Our Ref: 16/15849
SSD 6917
15/02841

**Oakdale South Industrial Estate (SSD 6917)
Vegetation Management Plan**

I refer to the meeting on 30 November 2016 between the Department, the Office of Environment and Heritage (OEH) and yourself and your email dated 9 December 2016 seeking approval of the Vegetation Management Plan (VMP) for the Oakdale South Industrial Estate, pursuant to Condition E47 of SSD 6917.

Figure 1-1. SSD 6917 MOD 1 VMP areas (left) and amended VMP areas (right)

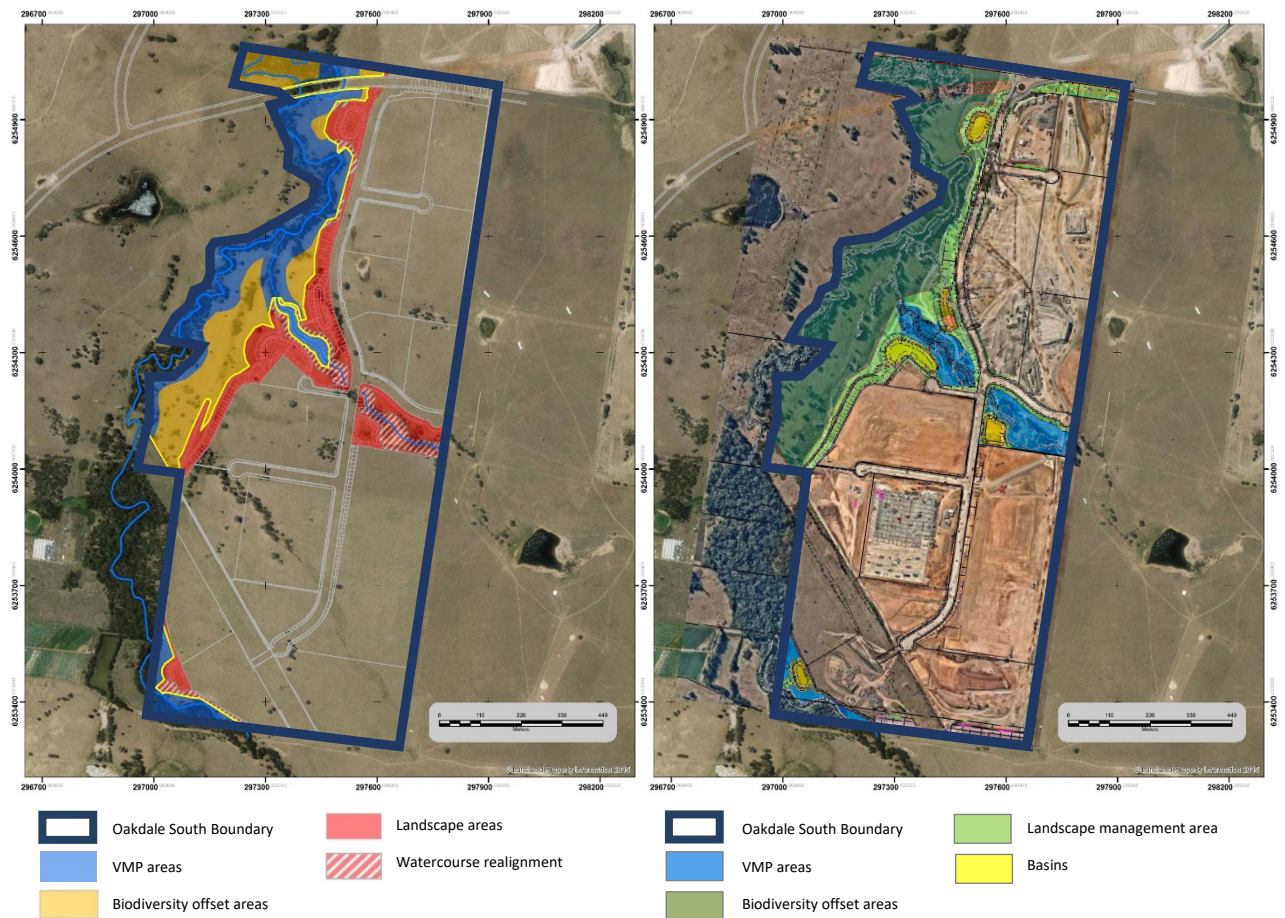
- updating of the executive summary;
- updating all plans and figures in the VMP to separate the geographic overlap between the riparian corridor and biodiversity offset area;
- removal of all references to on-going management works after a 5 year period; and
- removal of other landscaping zones which are not part of the bio-banking area covered by other conditions of consent including:
 - defensible zones and associated embankments;
 - bio-retention basins; and
 - areas of water course re-alignment works.

- clearly delineate the riparian zone and proposed on-site offset area in all maps and figures;
- reflect the layout of the Oakdale South Industrial Estate as currently approved; and
- ensure the management of the riparian zone aligns with the management actions required under the *BioBanking Assessment Methodology 2014*.
